Please ask for: Sian Eggington
Email: sian.eggington@terraquest.co.uk
Telephone: 0121 2341390
Our Ref: LU/281/20/HH
Your Ref:
Date: 15th October 2020

Application for Planning Permission for Works or Extension to a Dwelling

Development: Ramp connecting to existing pathway to provide disabled access to front entrance.
Location: 34 Jays Close Littlehampton BN17 6HQ

34 Jays Close

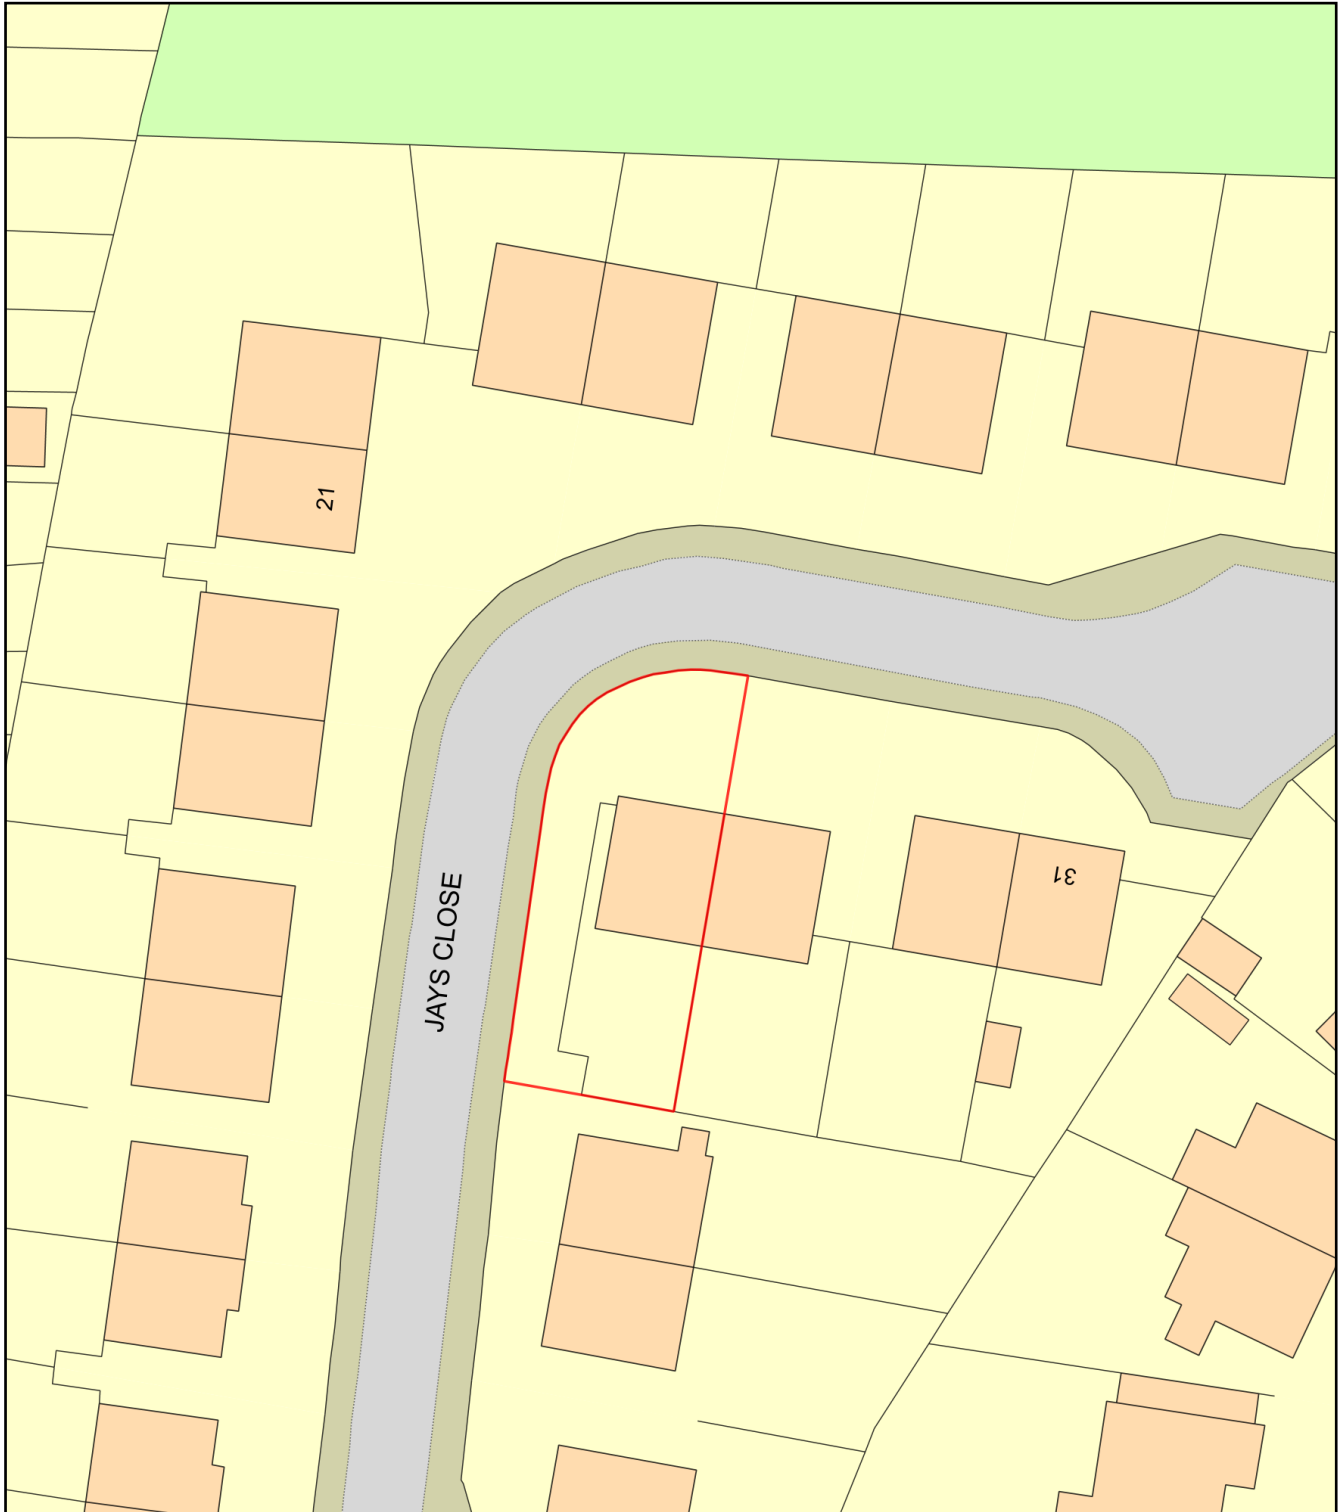
Dimensions: You are required to include dimension on the block plan from the proposal to all site boundaries.
